El Paso County Planning Department
2880 International Circle, Suite 110
Colorado Springs, CO 80910
Attn: Kari Parsons

Re: Letter of Intent in Support of Organization of Bent Grass Commercial Metropolitan District

EXHIBIT A.3 – PROPOSED INFRASTRUCTURE AND AMENITIES MAPS

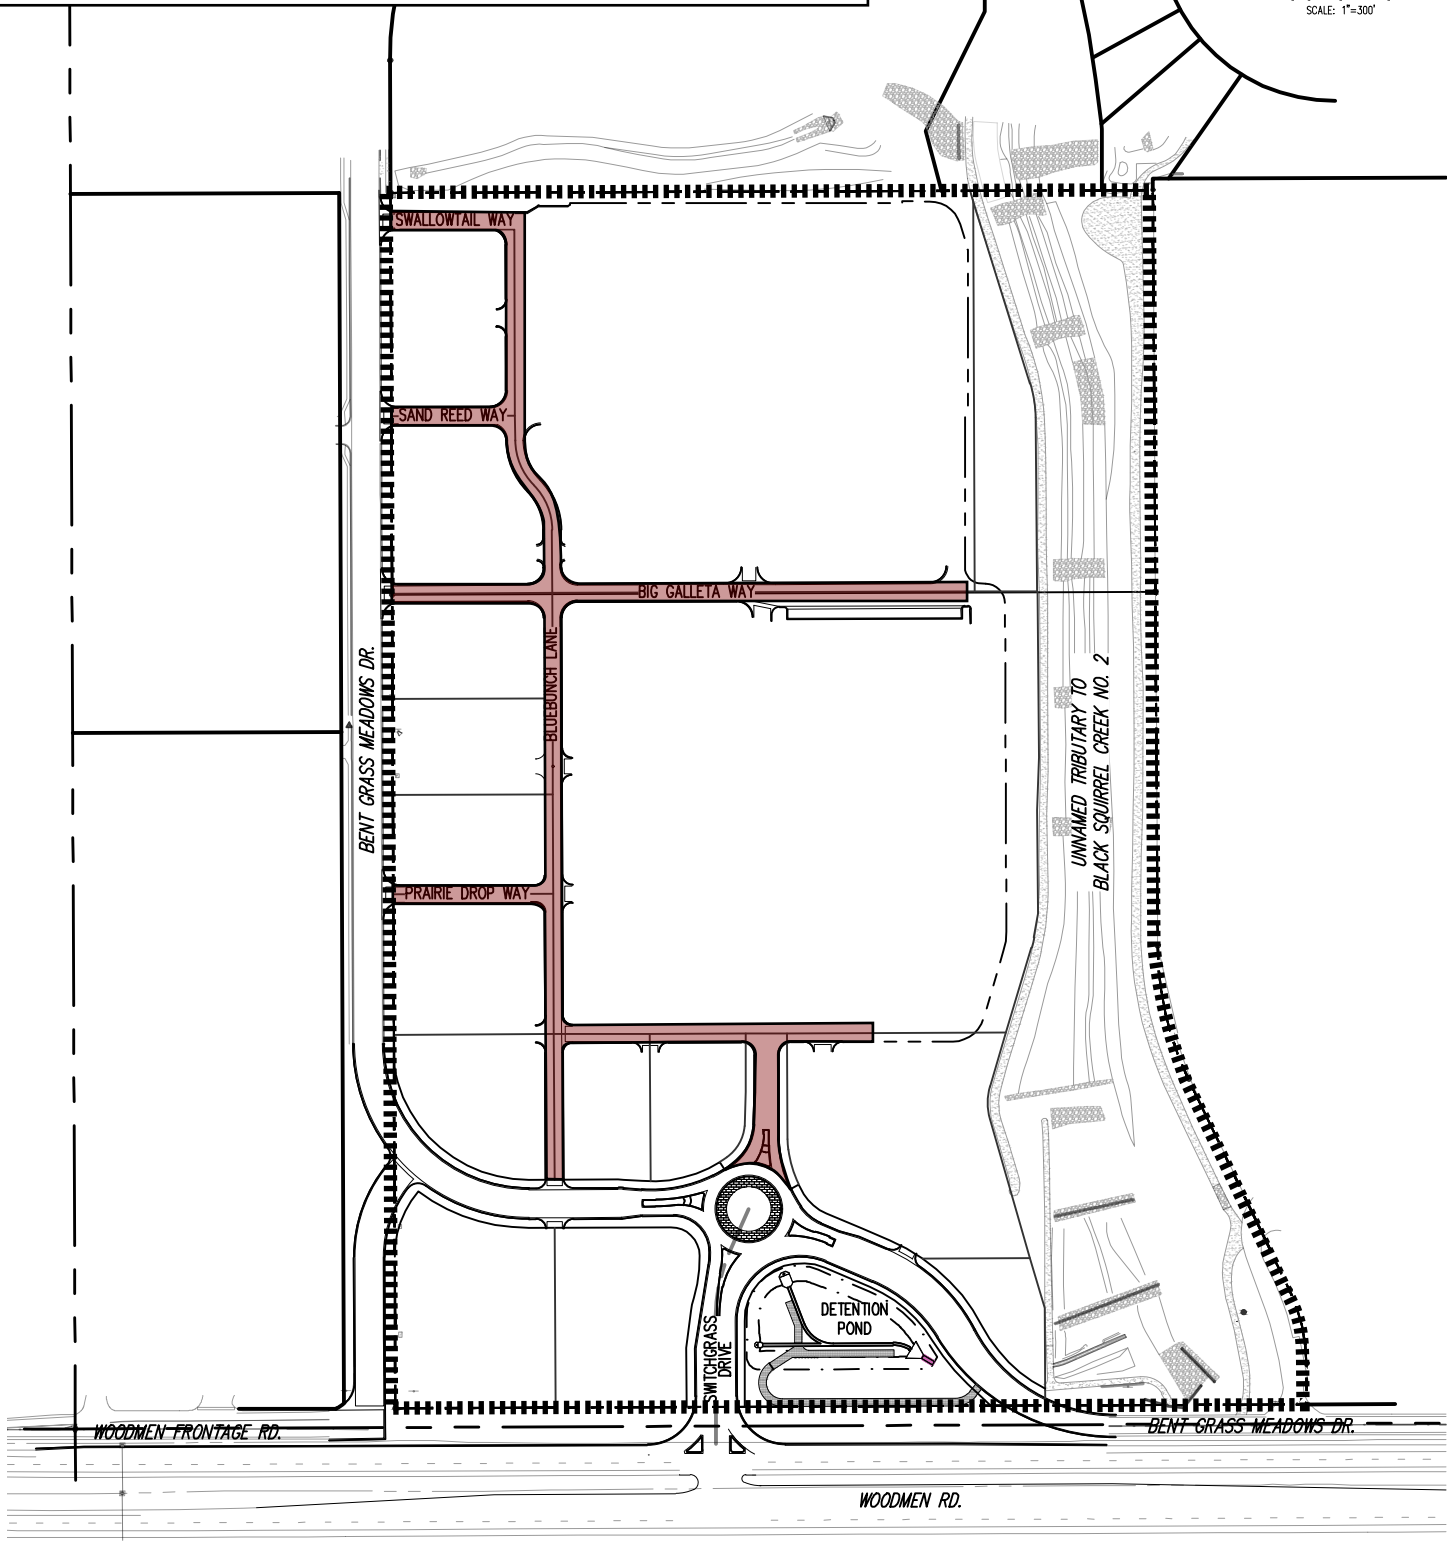
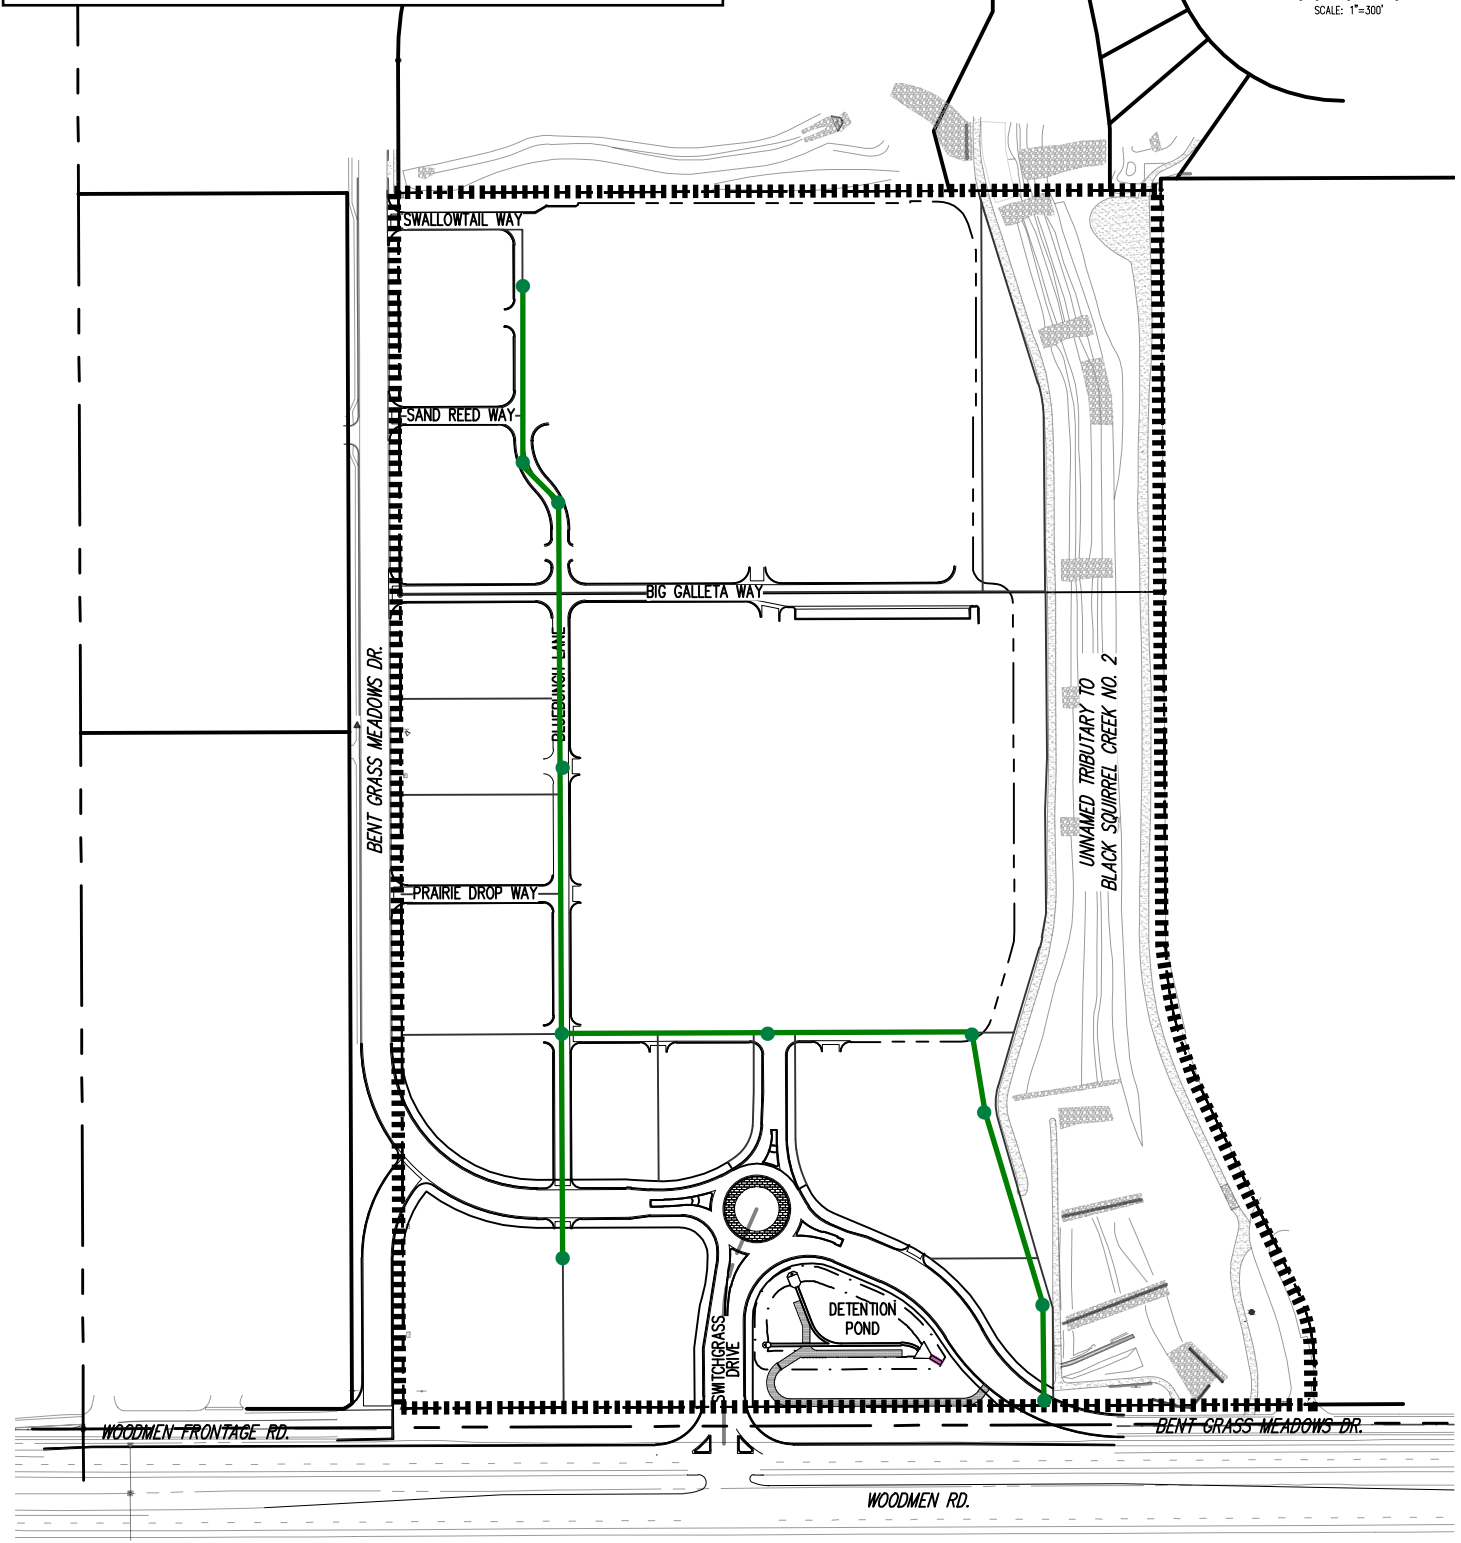
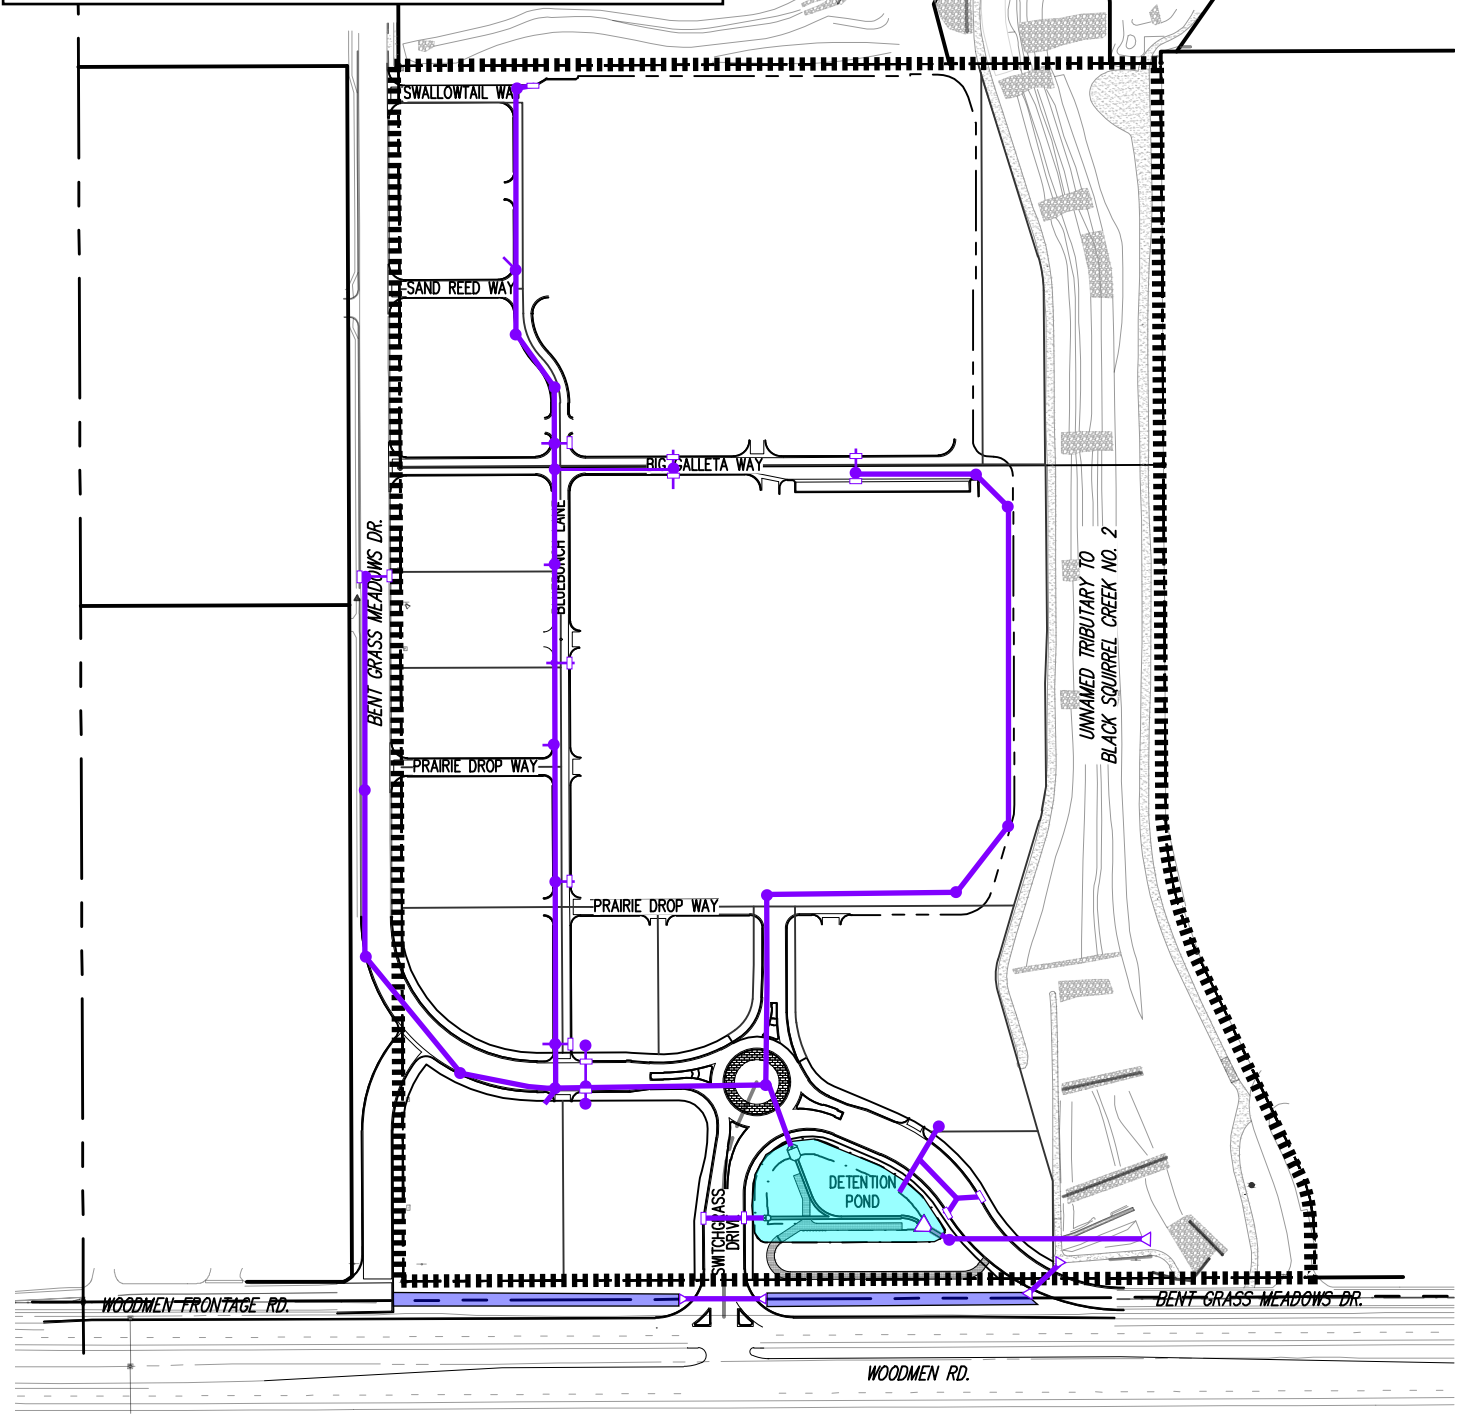
later the LOI says "the stormwater quality ponds" is there proposed to be one or multiple ponds?

later the LOI says "the stormwater quality ponds" is
there proposed to be one or multiple ponds?

the stormwater quality ponds
